SNC - Final Comments on draft DCO (Doc 3.1E)

dDCO - Doc 3.1E Part / paragraph Title / Number.	Issue	Comment
Part 1 - Preliminary - Interpretation p. 2	Definition of 'maintain'	<p>The definition provided currently includes the words “clear, alter, refurbish or improve”. The inclusion of these activities extends the scope of maintenance beyond the commonly accepted definition of ‘maintain’.</p> <p>The definitions provided in the Cambridge, Oxford and Collins English dictionaries respectively are set out below.</p> <p>“ to keep a road, machine, building, etc. in good condition: https://dictionary.cambridge.org/dictionary/english/maintain</p> <p>"Keep (a building, machine, or road) in good condition by checking or repairing it regularly". https://en.oxforddictionaries.com/definition/maintain</p> <p>if you maintain a road, building, vehicle, or machine, you keep it in good condition by regularly checking it and repairing it when necessary. https://www.collinsdictionary.com/dictionary/english/maintain</p> <p>The definition within the dDCO would allow for works for ‘alteration’, ‘clearance’, ‘refurbishment’ or ‘improvement’. It however provides no parameters to define the extent of these

Figure 17: Parameters Plan

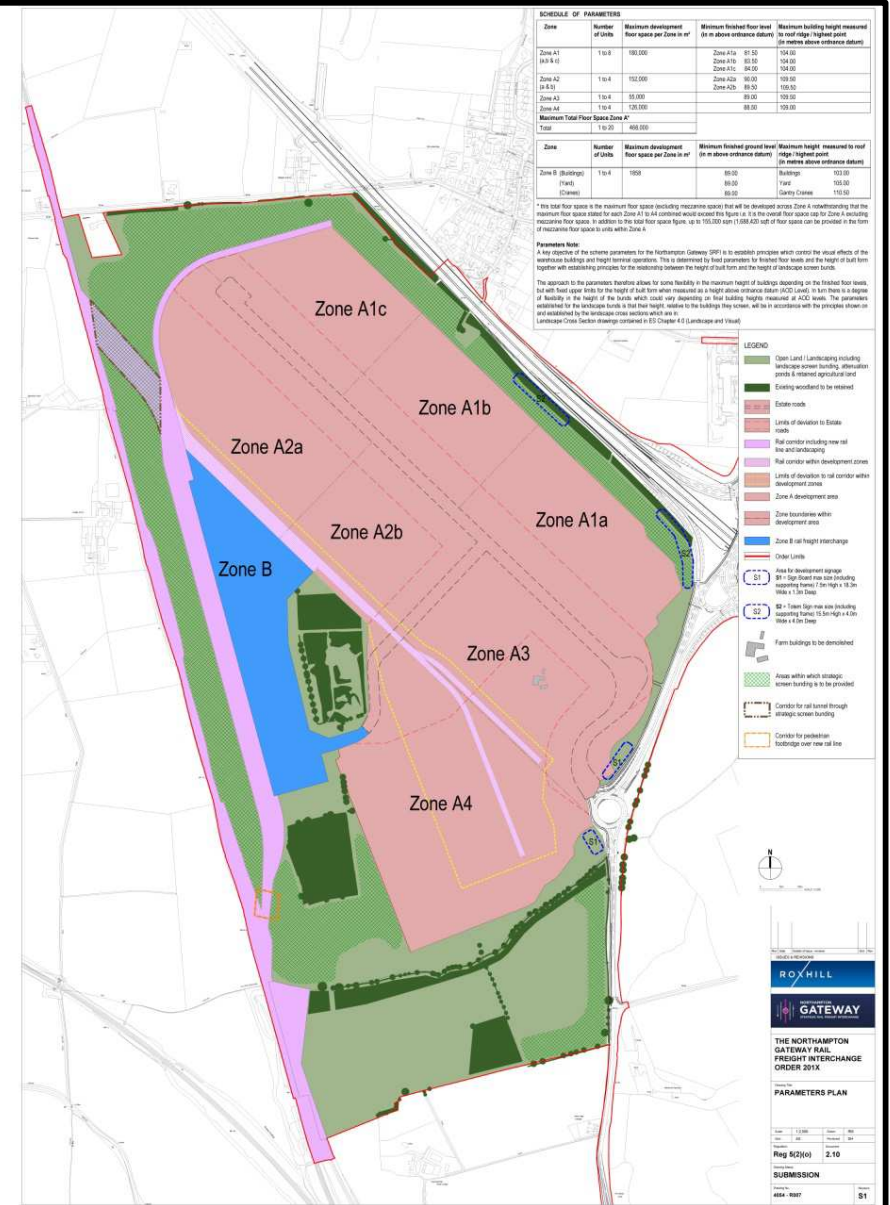
<p>SCHEDULE 1 AUTHORISED DEVELOPMENT PART 1 NSIP: THE CONSTRUCTION OF A RAIL FREIGHT INTERCHANGE Regulation 46 (4)</p>	<p>Works No.4 (5) Works No6 (3) References to advertisements within areas S1 and s2 shown on the parameters plan.</p>	<p>References to the display of advertisements in Works No.4 and Works No.6 in the draft DCO should be omitted.</p> <p>No satisfactory argument is made to justify the inclusion within the DCO of works for the display of advertisements within areas S1 and S2. The Town and Country Planning (Control of Advertisements) (England) Regulations</p>

dDCO - Doc 3.1E Part / paragraph Title / Number.	Issue	Comment
	<p>46(4) dis- applies Regulation 4 of the T &CP Control of Advertisements) (England) Regulations 2007.</p>	<p>2007, as amended, provide s the appropriate regime for the control of advertisements and this should extend to all parts of the development site. The existing regulations provide the appropriate procedure to ensure the impact of advertisements on amenity and highway safety can be properly assessed.</p> <p>The location of site S2 will be visible from the M1 motorway. The display of advertisements in this location may not be desirable in principle, given the sole purpose will be to attract the attention of users of the motorway.</p> <p>The extent to which an advertisement will impact on highway safety must be assessed through consultation with the relevant highway authority. The details of the proposed signs and the appropriateness of the location are both significant to assessment of the impact on highway safety.</p> <p>It cannot be considered to be in the interest of proper planning to grant planning permission in principle for development where there is a reasonable prospect that whatever the eventual form this will be considered to give rise to an unacceptable impact for highway safety.</p> <p>This situation would be avoided by ensuring the appropriateness of the location for advertisements can be considered at the same time as the detail of the signs. The Town and Country Planning (Control of Advertisements) (England) Regulations 2007 provides the appropriate regime for this.</p> <p>Schedule 2 Part 1 Requirement 8(2)(n) makes provision for details of</p>

dDCO - Doc 3.1E Part / paragraph Title / Number.	Issue	Comment
		<p>advertisements within location S1 and / or S2 to be submitted to an approved in writing by the relevant planning authority. Regulation 46 (4) dis-applies Regulation 46 (4)of the T &CP Control of Advertisements) (England) Regulations 2007 with respect to locations S1 and S2.</p> <p>If the references to Works for advertisements in locations S1 and S2 are omitted from the draft DCO then Regulation 46 (4) and the requirement at 8(2)(n) is no longer required and should be omitted . If the provision is retained with respect to location S1 then the Regulation 46 (4) and Requirement 8(2)(n) should be amended to refer to S1 only.</p>
Requirement 8 (1)	Amendment to wording to clarify meaning and purpose.	<p>Revise to read as follows :</p> <p>8.(1) “The details of each component of the authorised development on the main site referred to in requirement 3 must be in accordance with the parameters plan and the principles set out in the design and access statement. The design and access statement can may be reviewed and updated by the undertaker. in agreement with A revised design and access statement will not take effect unless it has been submitted to and approved in writing by the relevant planning authority”.</p>
